# DRB CASE ACTION LOG

| Project Name <u>RIVERVIEW ADDITION</u>        |                            |

**TO:** Sheran Matson, DRB Chair  
**FROM:** Carmen Marrone, Staff Planner  
**RE:** **Project #1003169, 04DRB 00321, Rio Vista Church**

## DEVELOPMENT REVIEW BOARD TRANSPORTATION DEVELOPMENT Standard Comment Sheet

A1	SITE PLAN PHASE 1
1"=30'-0"

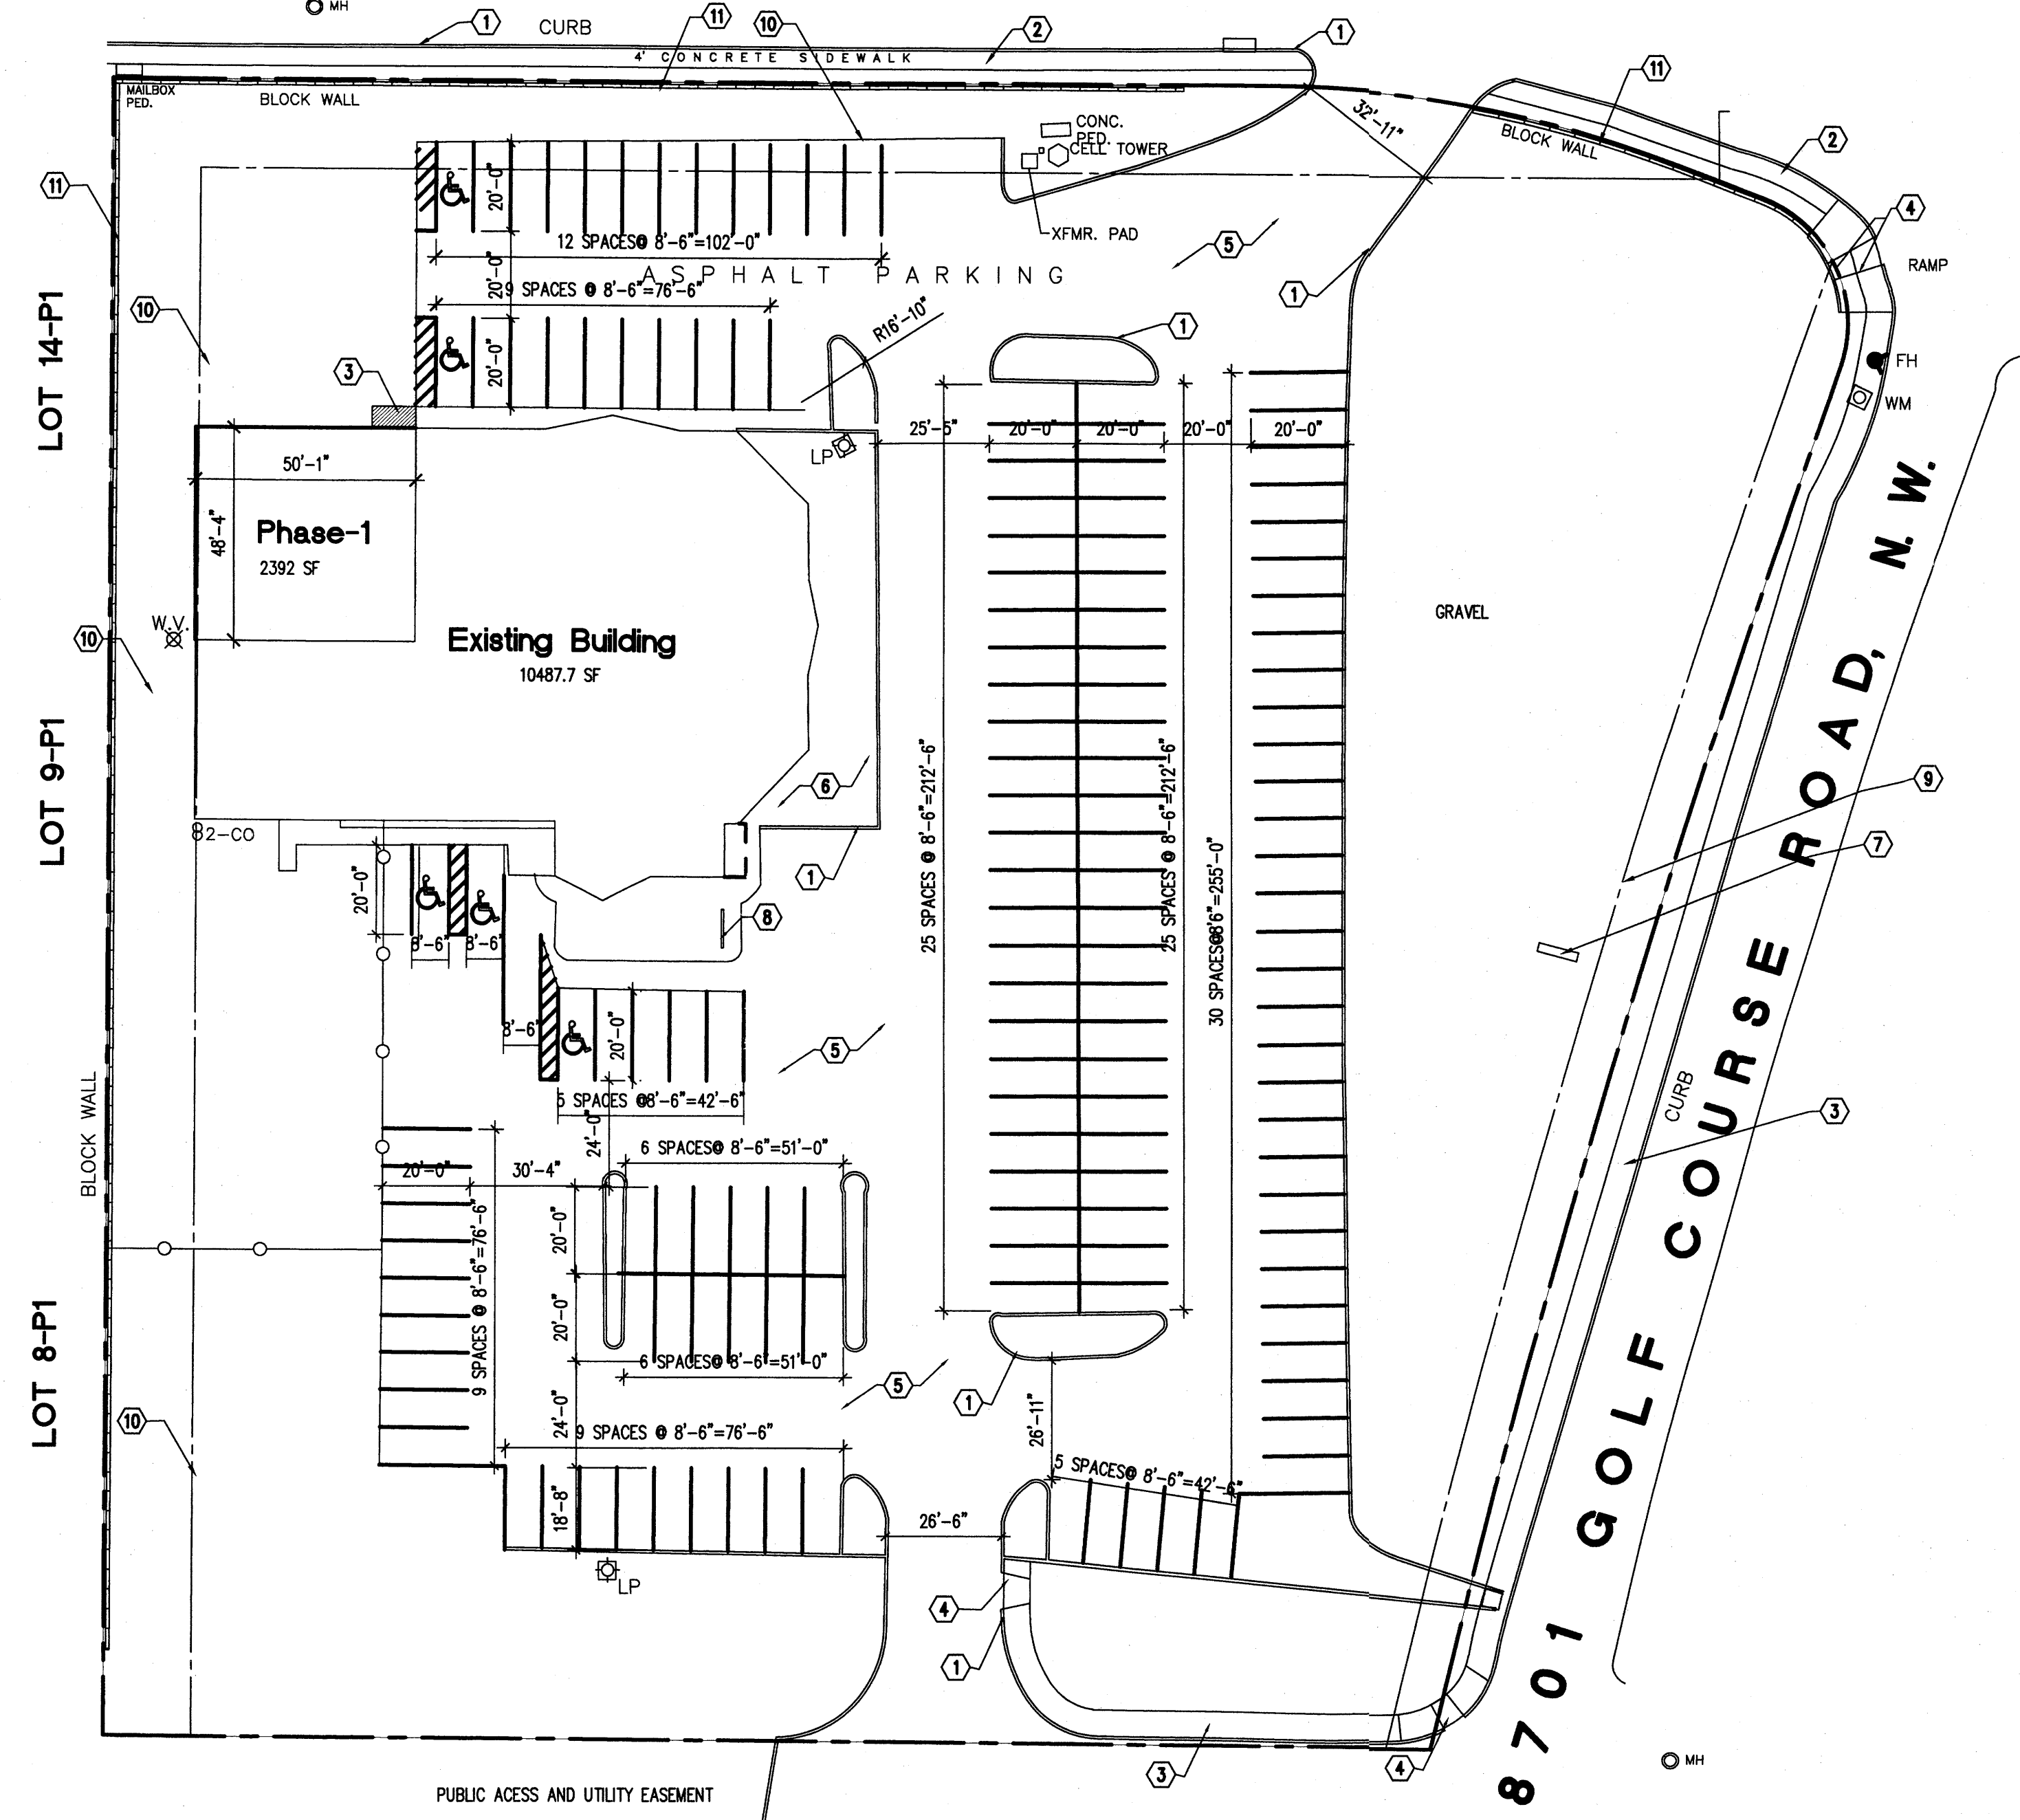
| No. | Comment   |
|-----|---|
| ③   | WHY ISN'T SIDEWALK @ PROPERTY LINE                |
| ④   | SIGHT DISTANCE W/ BLOCK WALL                      |
| ⑤   | HICED RADII LABELED is 25' 15' etc                |
| ⑥   | 18' SIGN WILL OVERHANG ONTO 6' S.W. - NOT ALLOWED |
| ⑦   | 5' MINIMUM KEYWAY @ DEADEND                       |

C11	DUMPSTER ENCLOSURE PLAN
1/4"=1'-0"	C-1

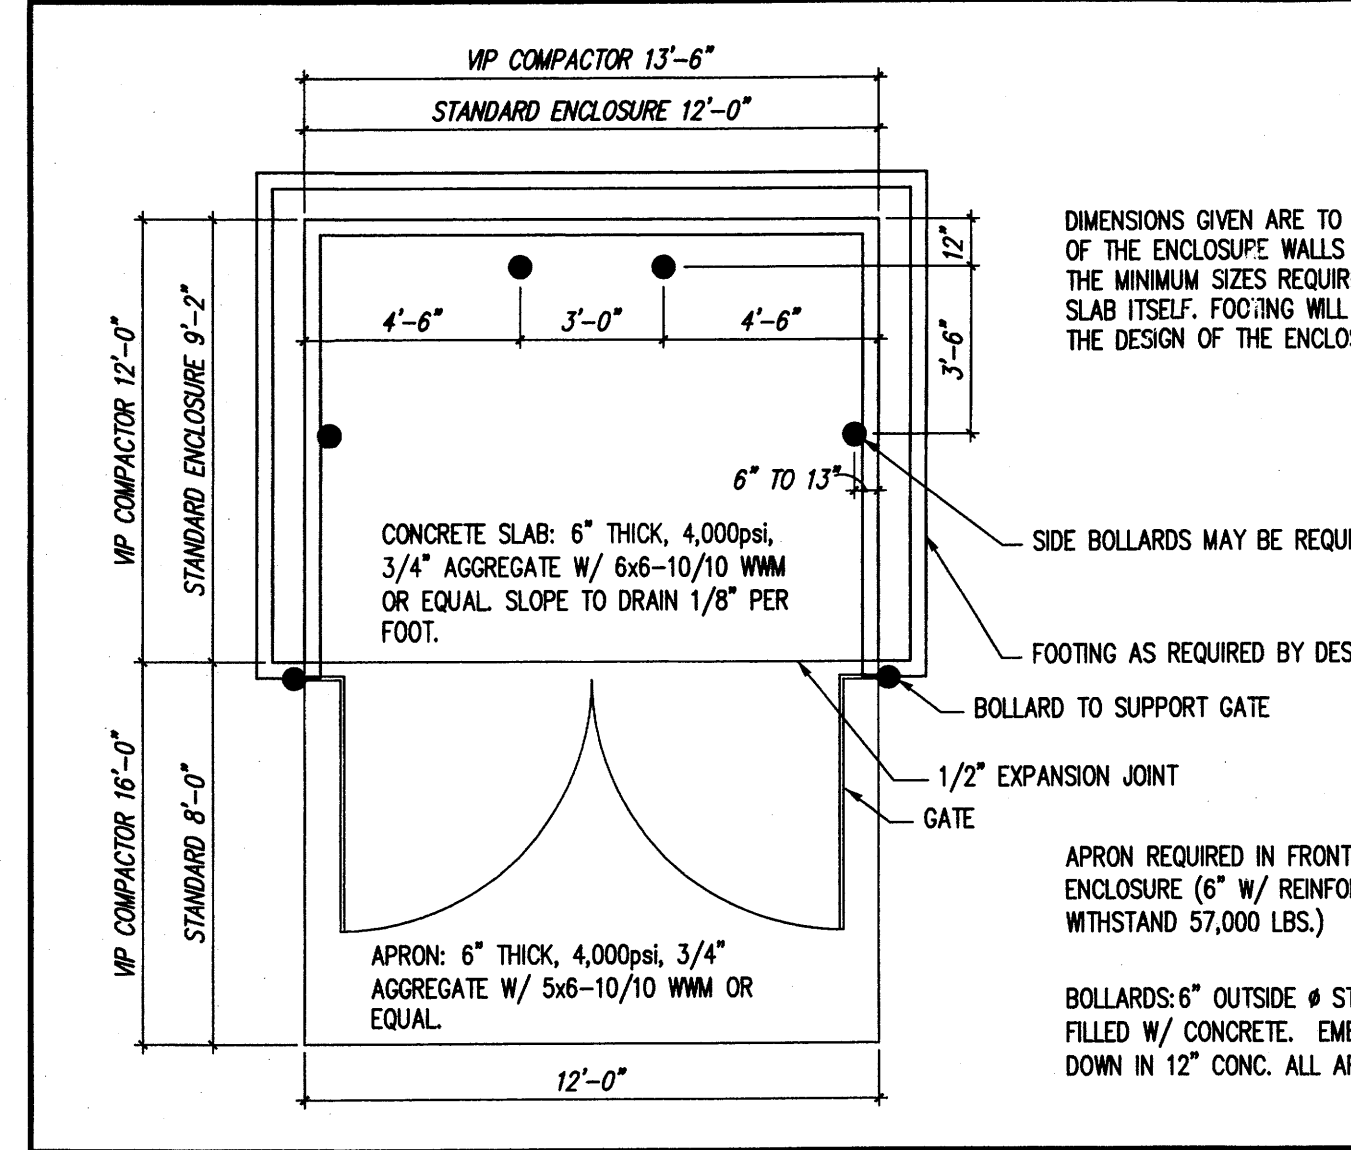
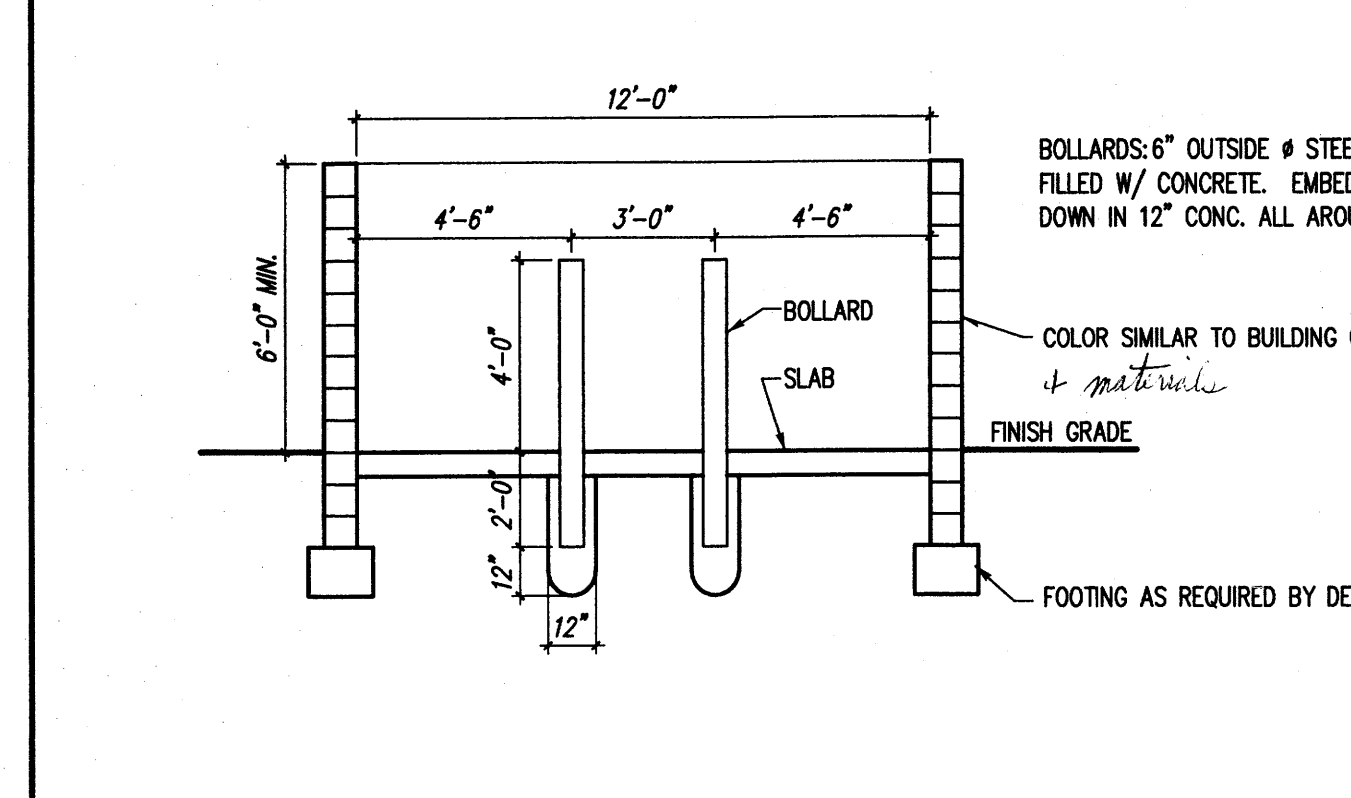
Condition #7: "The dumpster enclosure shall be similar in color and materials to the church." Page C-2 indicates enclosure color similar to building color but makes no reference to materials. Applicant should indicate stucco materials, which is similar to church materials, for the enclosure.

8. On C-2 the dumpster enclosure has designated color and finish to match building.
